**Subject:** FW: Planning Application No: 3/2013/0100 - Elmridge Farm.

**From:** Bloomer, David [mailto:David.Bloomer@lancashire.gov.uk]

Project:
 Proposed Development
 Elmridge Farm, Elmridge Lane,
 CHIPPING PR3 2NY
 Drawing title:
 Overall Site Layout

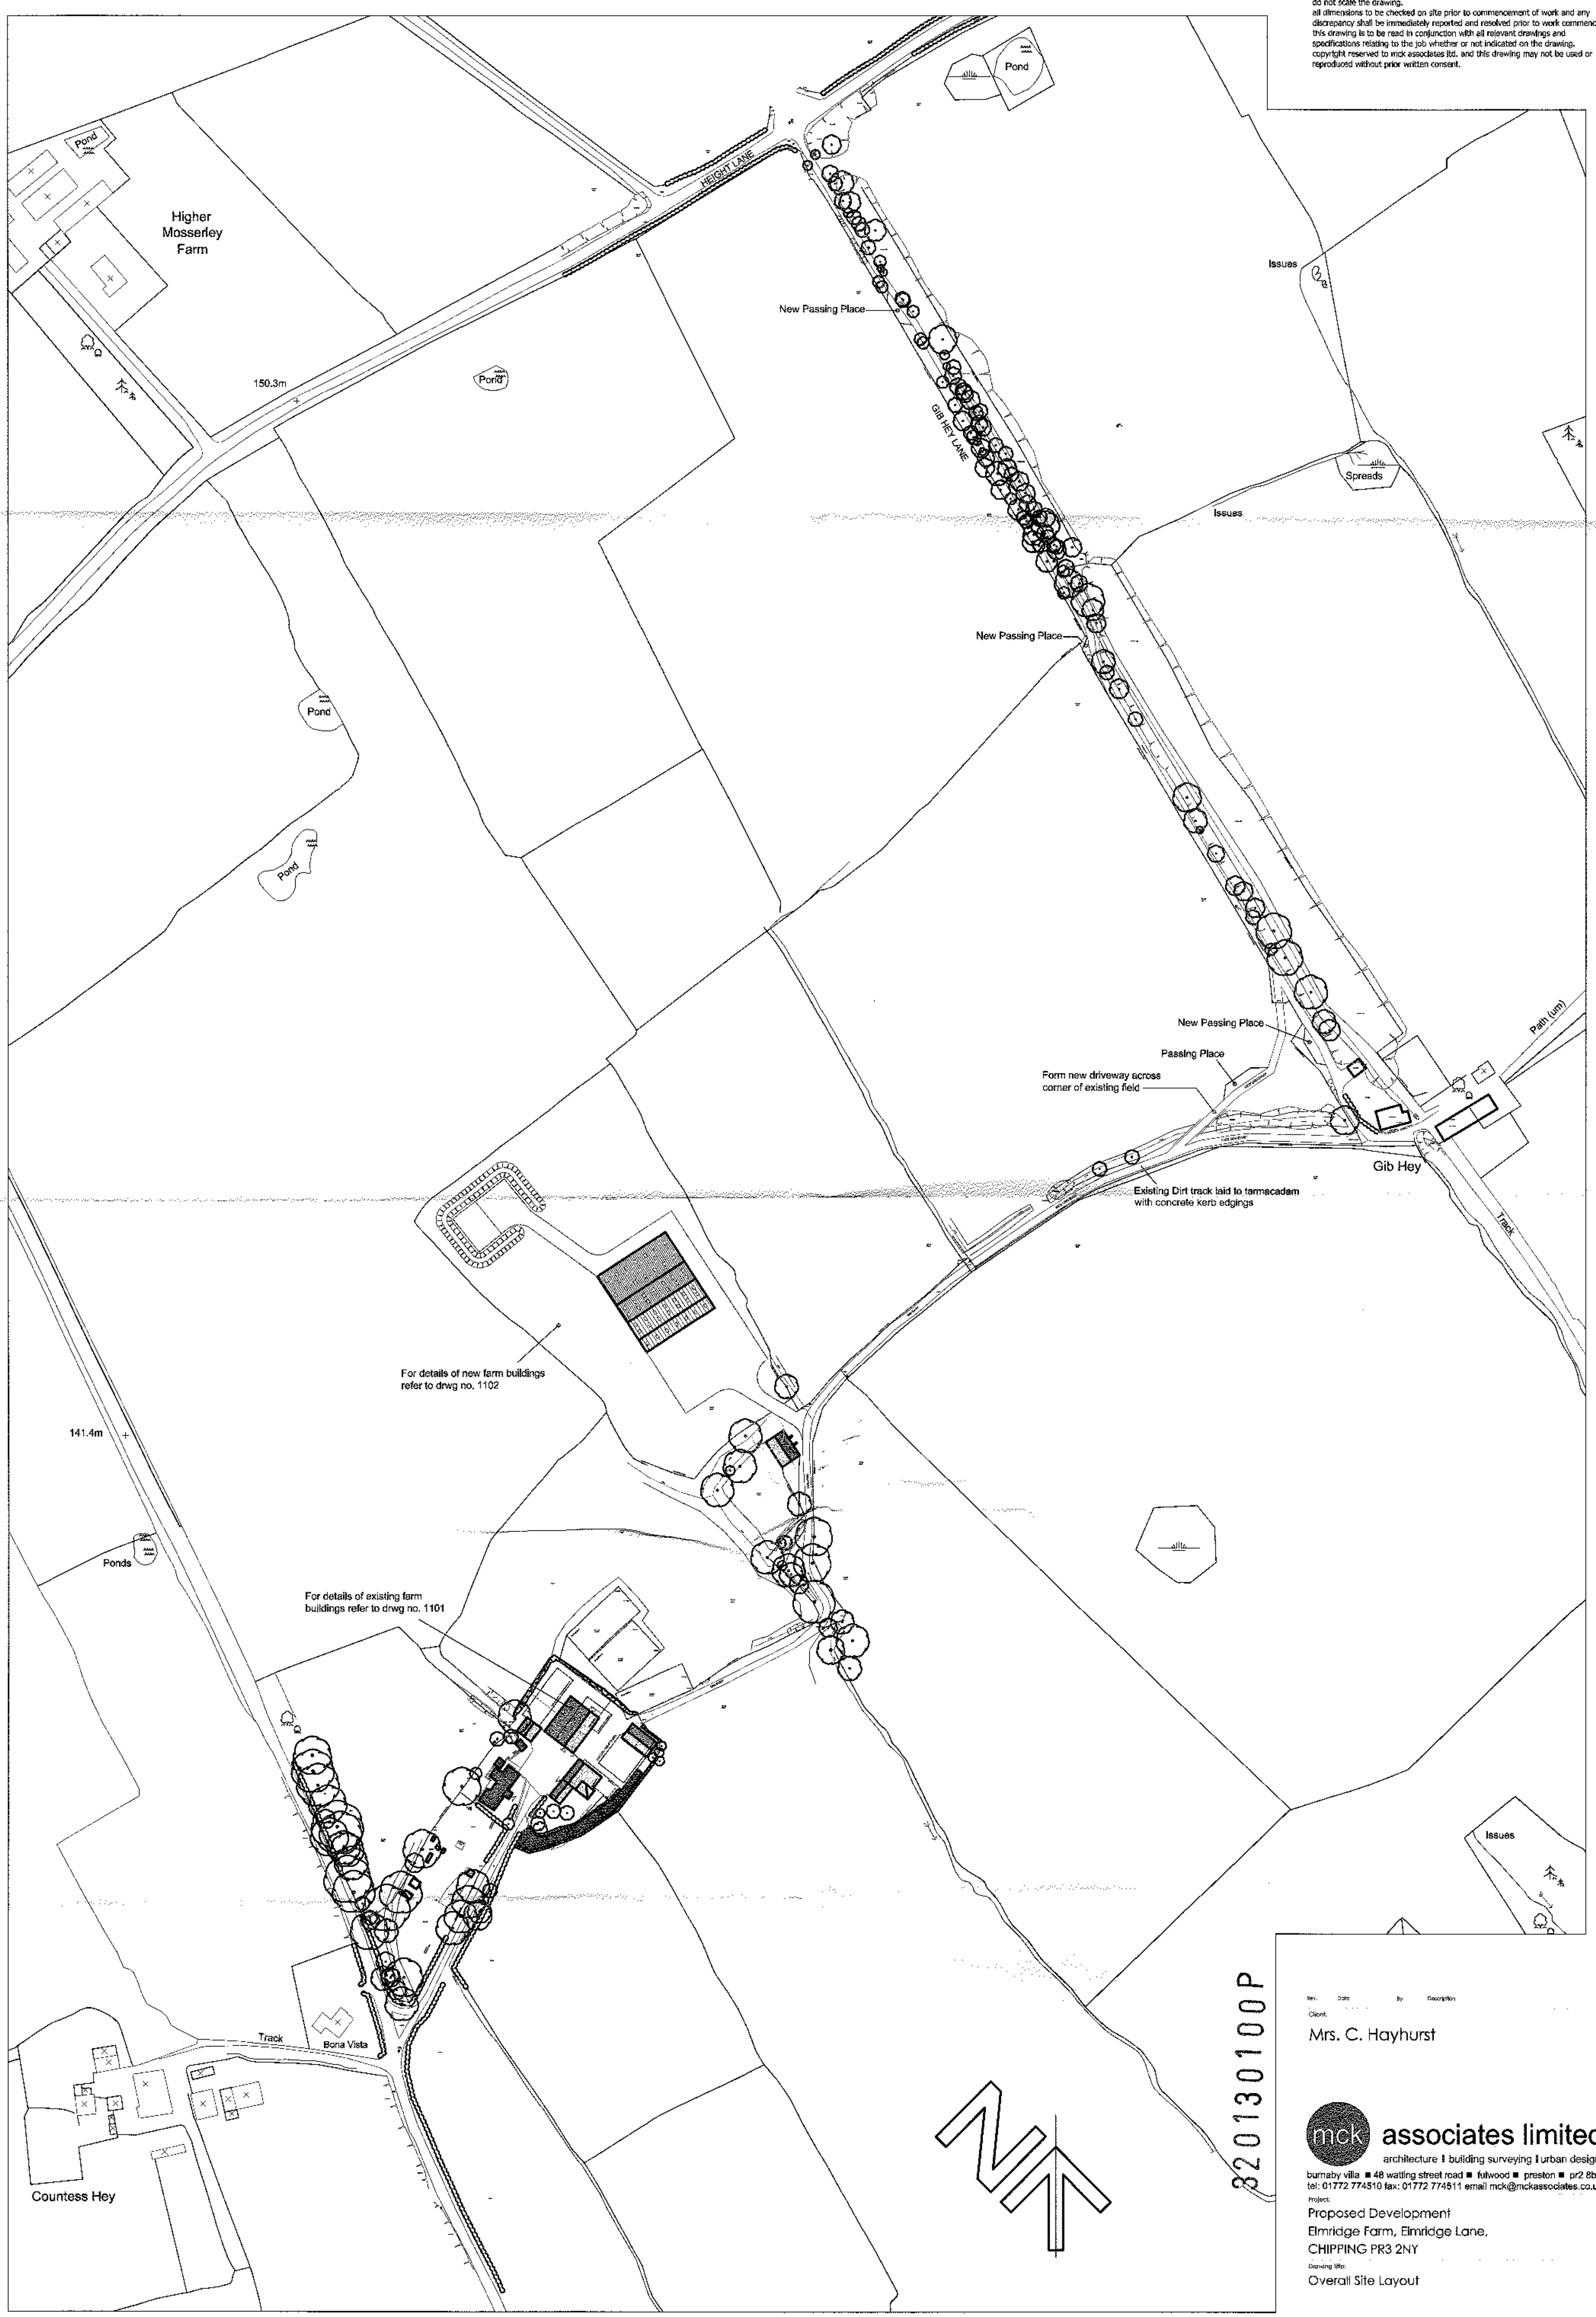
I have now had the opportunity to have a look at the application site. The proposal is to increase the number of dwelling at the site brought about by the conversion of 3 barns to 4 dwellings. The proposal has the potential to increase the level of traffic entering /leaving the site which in itself will generate conflict between opposing vehicles entering /leaving the site. Whilst I previously mentioned that this could be addressed by altering the junction, having visited the site it is clear that the sight lines , particularly to the left, are substandard and will require substantial earthworks to remedy. Due to this I would have to recommend refusal on the grounds that the increased traffic would be using a substandard junction to the detriment of the safety of road users.

There may be merit in considering the relocation of the access further north . This would not achieve the necessary sightlines but it would be a significant benefit over the current access and may, subject to design, offer sufficient mitigation to reconsider my recommendation for refusal
